**CITY OF ALBUQUERQUE
PLANNING DEPARTMENT**

**July 9, 2014
DRB Comments**

PROJECT # 1009881

**RE: Lot 4-10 & 23-29, Block 29, Tr. A Unit B, North Albuquerque
Acres**

PRELIMINARY PLAT OF
EAGLE CREST SUBDIVISION
 BEING A RE-PLAT OF LOTS 4-10 AND LOTS 23-29
 BLOCK 28, TRACT A, UNIT B, NORTH ALBUQUERQUE ACRES
 PROJECTED SECTION 13, TOWNSHIP 11 NORTH, RANGE 3 EAST, N.M.P.M.
 ELENA GALLEGOS GRANT
 ALBUQUERQUE, BERNALILLO COUNTY, NEW MEXICO
 DECEMBER 2013

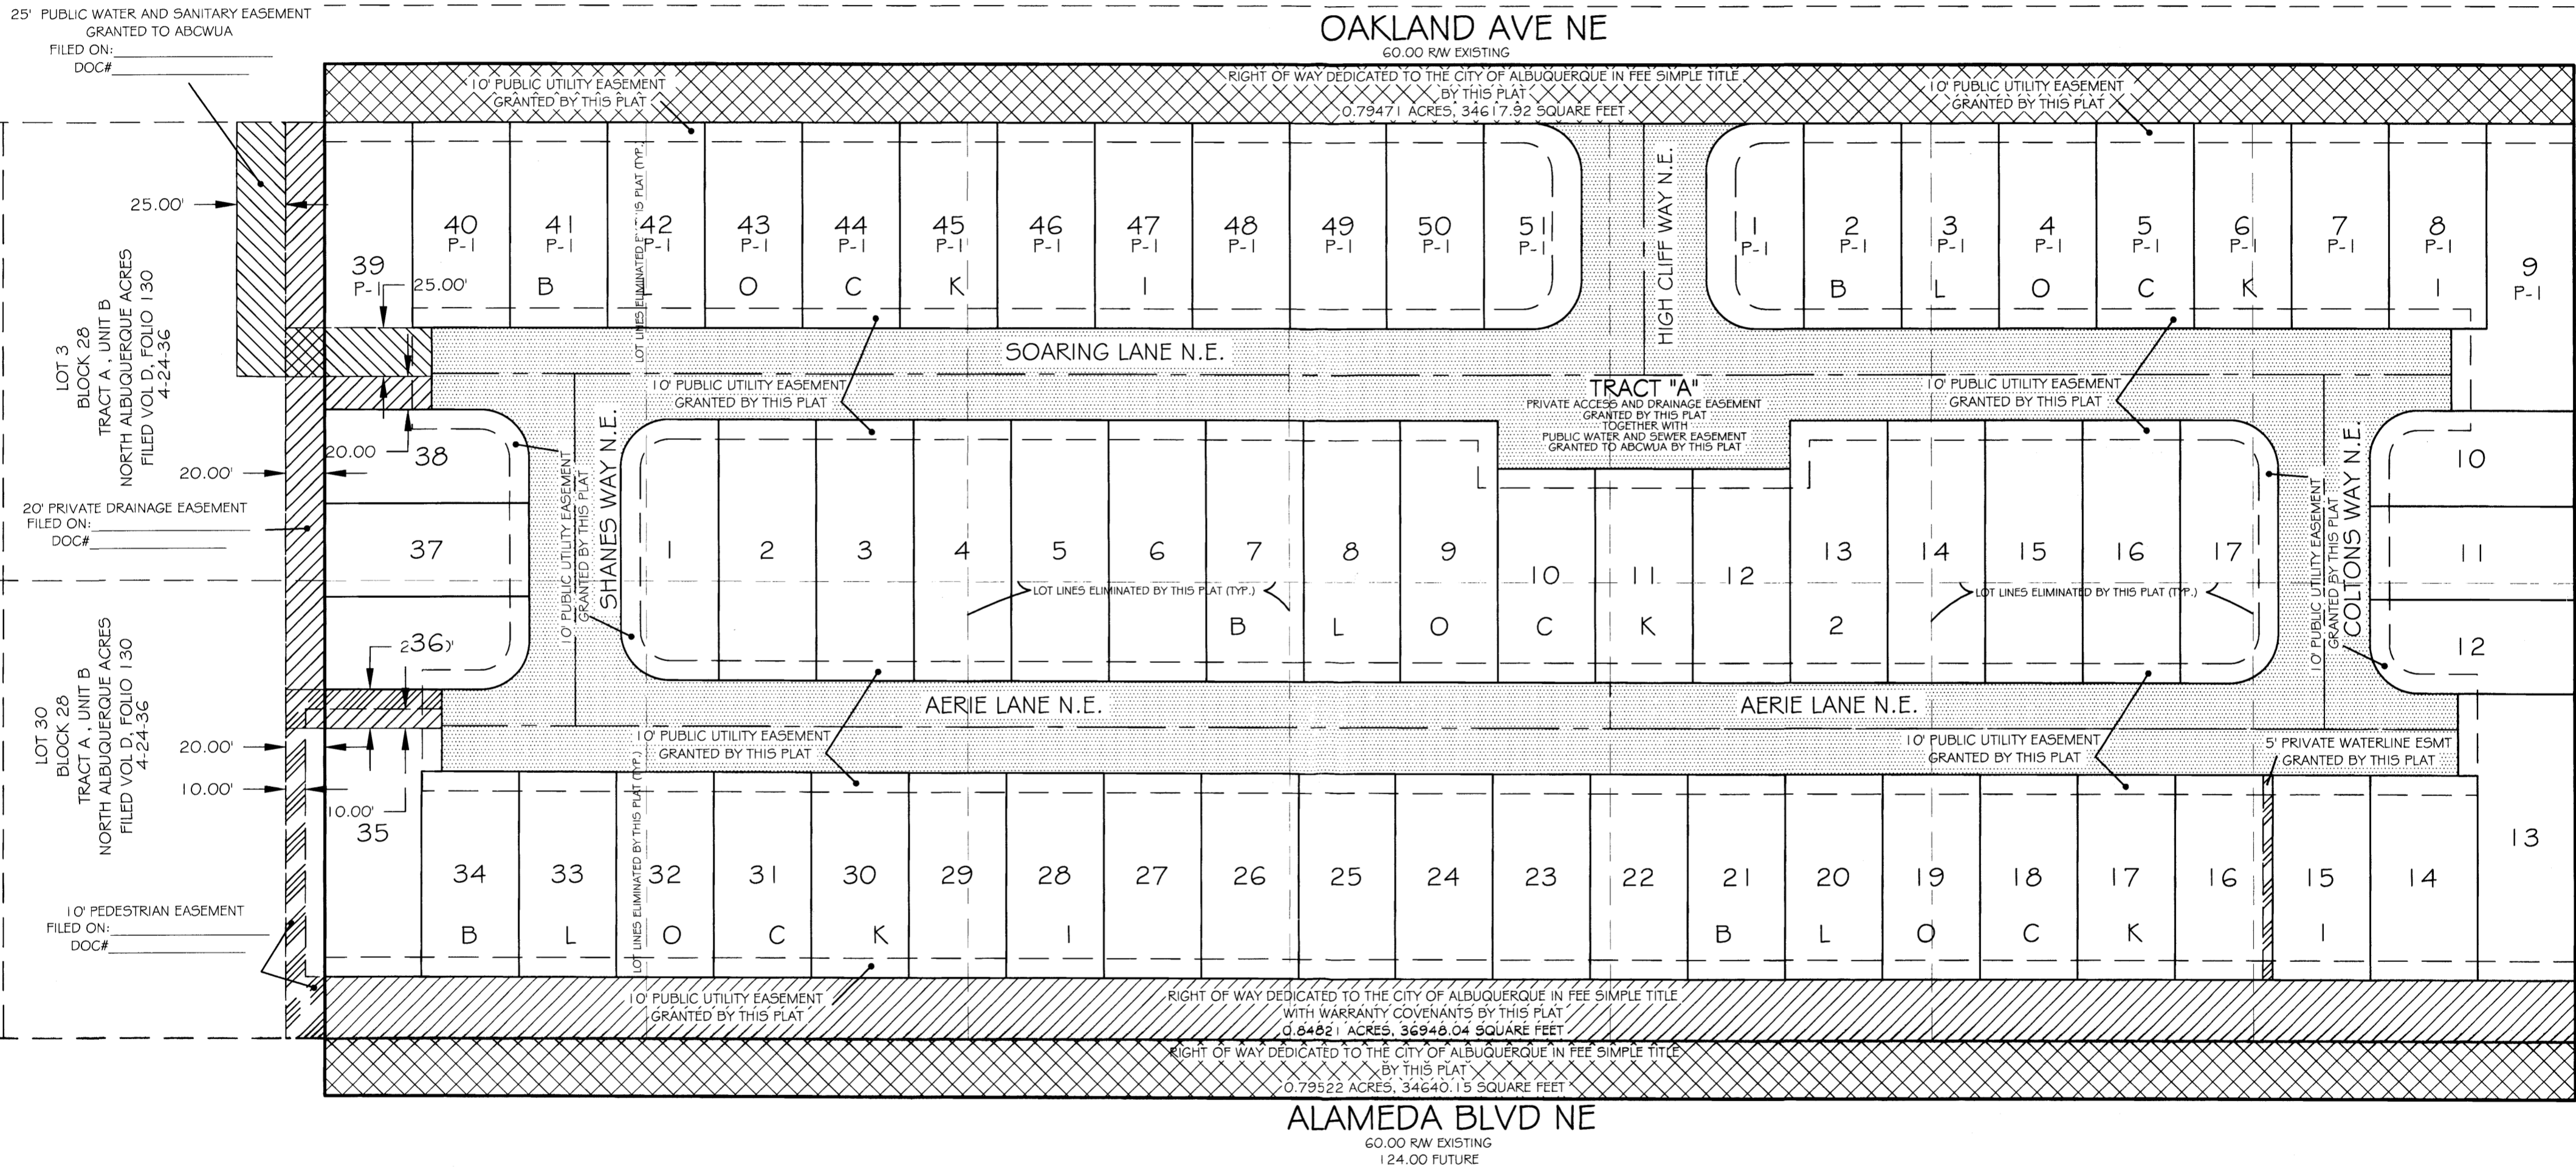
The extent of Tract "C" is not clear, and the proposed pedestrian access to Alameda Blvd on the east side of the subdivision does not appear adequate; more detail is needed regarding interface with proposed Lot 6. Refer to comments from Transportation Development and affected agencies plus any public hearing comments.
